# KITTTITAS COUNTY DEPARTMENT OF PUBLIC WORKS

## MEMORANDUM

TO: Trudie Pettit, Community Development Services  
FROM: Christina Wollman, Planner II CW  
DATE: September 12, 2008  
SUBJECT: Monahan Mountain Forest Tracts Large Lot Subdivision LL-08-04

Kittitas Co. Large Lot Subdivision NO. 08-04
 Portion of Section 14, Twp. 20N., Rge. 13E., W.M.
 Kittitas County, Washington

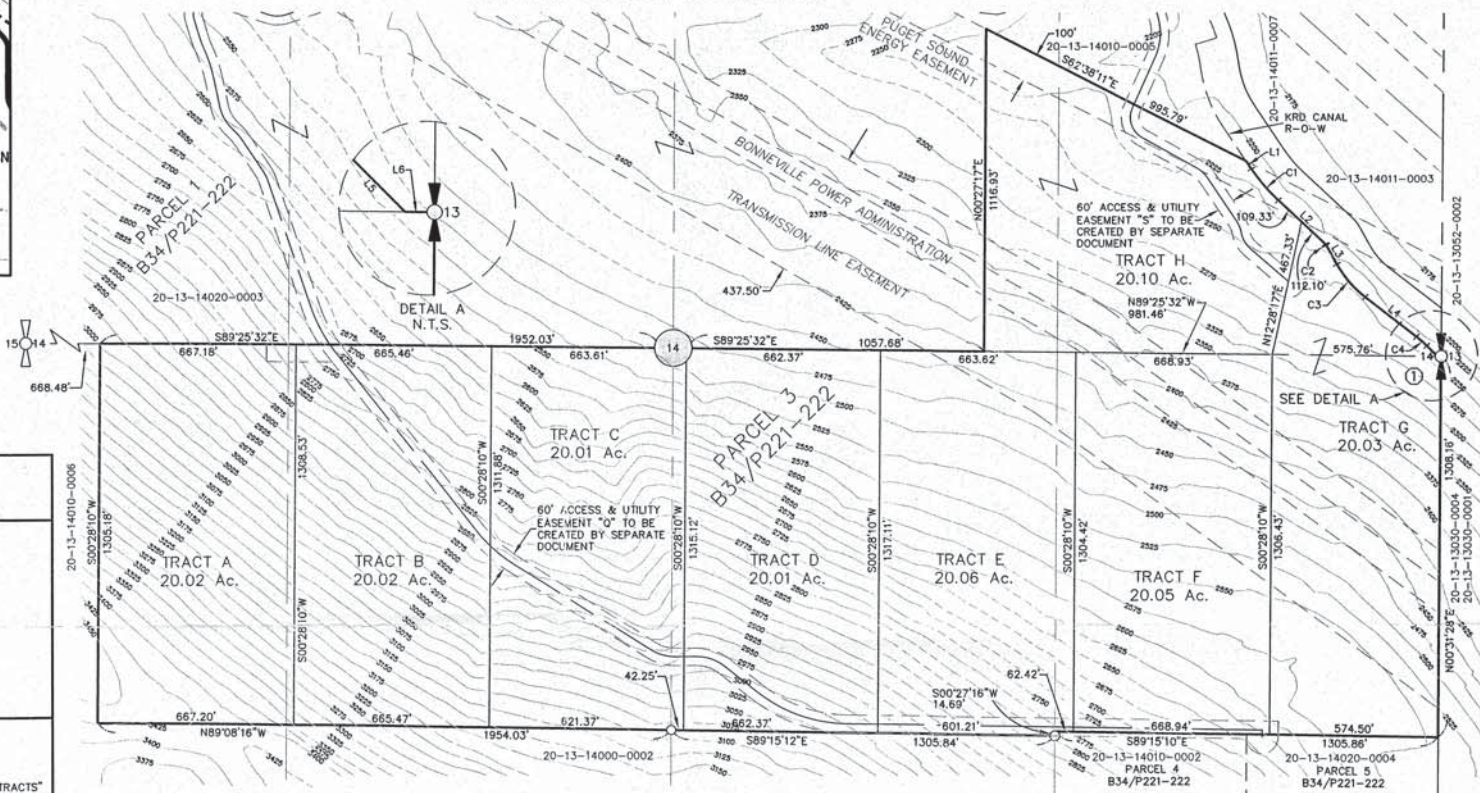
2. Site Distance: The access with Cabin Creek Road shall be improved to meet site distance if necessary. Site distance shall be included in the road certification

5. Tract A Access: The easement to Tract A shall be described on the final plat.
6. Certificate of Title: The certificate of title shall be submitted prior to receiving final approval.

7. Private Road Improvements: Access from Cabin Creek Road to the cul-de-sacs shall be constructed as a Low-Density Private Road. See Kittitas County Road Standards, 9/6/05 edition.

8. Cul-de-Sac: A cul-de-sac turn-around having an outside right-of-way easement diameter of at least 110 feet shall be constructed at the closed end of all dead-end roads serving 3 or more lots. The driving surface shall be at least 96 feet in diameter. Cul-de-sacs must also conform to the requirements specified by the 2006 International Fire Code. Contact the Fire Marshal regarding any additional cul-de-sac requirements.

- a. Access easements shall be a minimum of 60' wide. The roadway shall have a minimum width of 20', with 1' shoulders, for a total width of 22'.
  - b. Minimum centerline radius will be 60'.

- c. The surface requirement is for a minimum gravel surface depth of 6".
  - d. Maximum grade is 12%.
  - e. Stopping site distance, reference AASHTO.
